Your ref:	19 Shouldham Street - FP & LB...	Please reply to:	Mr Joshua Wilson
Our ref:	24/01322/FULL	Tel No:	07817095455
		Fee Queries:	0207 641 6500;
		Email:	planningreception@westminster.gov.uk;
Mr Christopher Smith Locksley Architects 11 Pembridge Mews Notting Hill London W11 3EQ		Incomplete Applications Town Planning & Building Control City of Westminster PO Box 732 Redhill, RH1 9FL	
		4 March 2024

Address: 19 Shouldham Street, London, W1H 5FL,

Proposal: Replacement of front door with timber panelled front door with glazed fanlight, replacement of rear windows with double glazed timber sash windows, new metal balustrade around rear lightwell, layout alterations and associated work. (Linked to 24/01323/LBC)

Issued for Planning		TBC	A
 LOCKSLEY ARCHITECTS			
Architect Details 11 Pembridge Mews, Notting Hill, London W11 3EQ info@locksleyarchitects.com 0207 206 2727			
Project 19 Shouldham Street			
Title Sash Window Detail			
Job No	Dwg No	Revision	
1115	D01	A

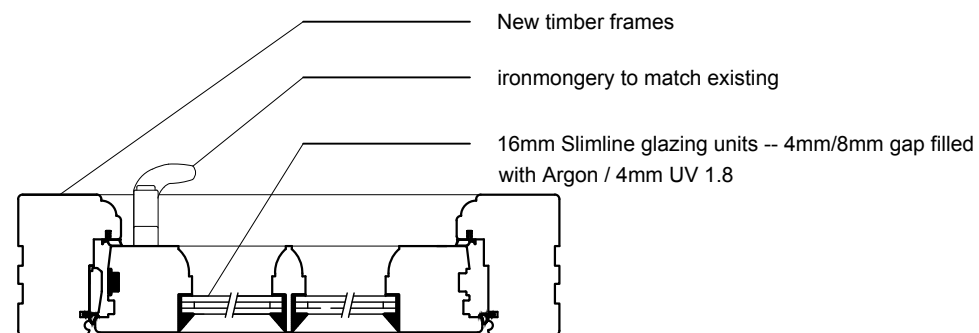
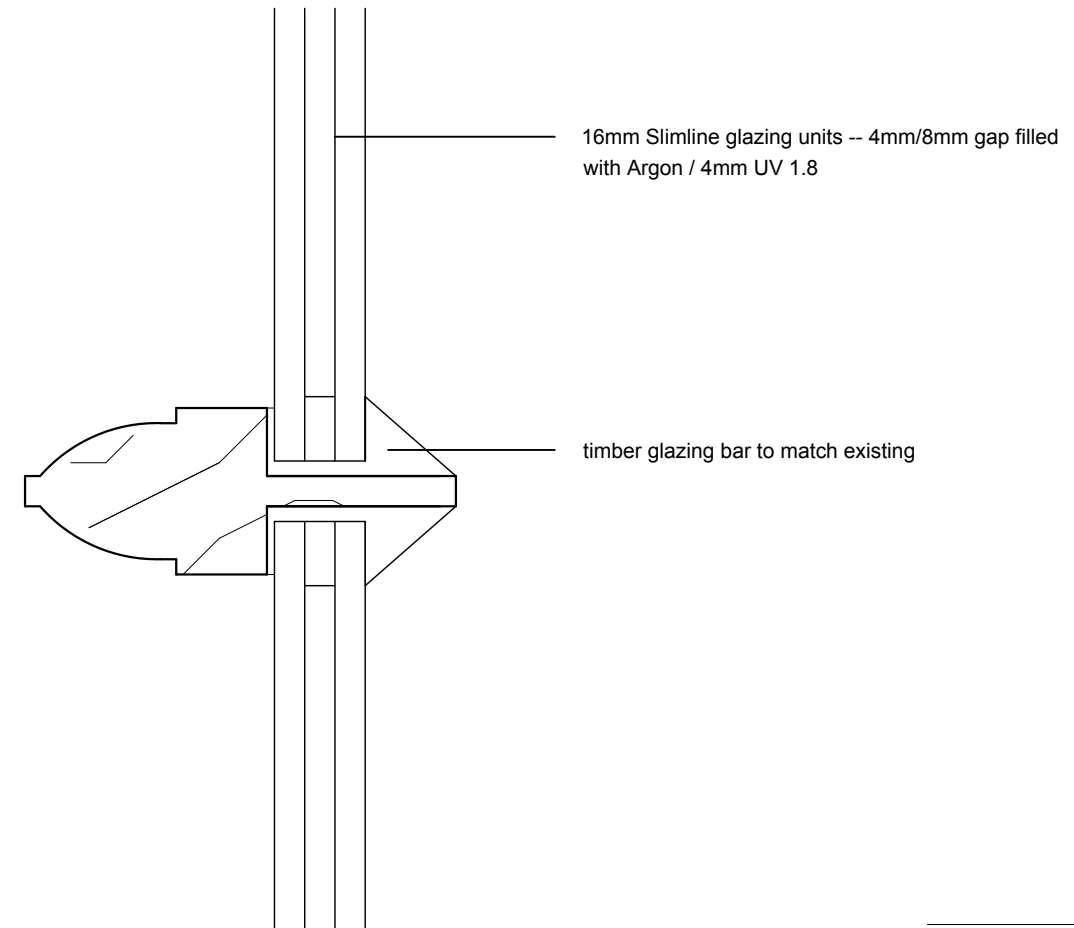
1 There are no detailed drawings of the windows, Therefore we cannot properly consider the impact of the alterations in heritage asset terms.
 - Please provide existing and proposed detailed drawings (section through) of the windows.
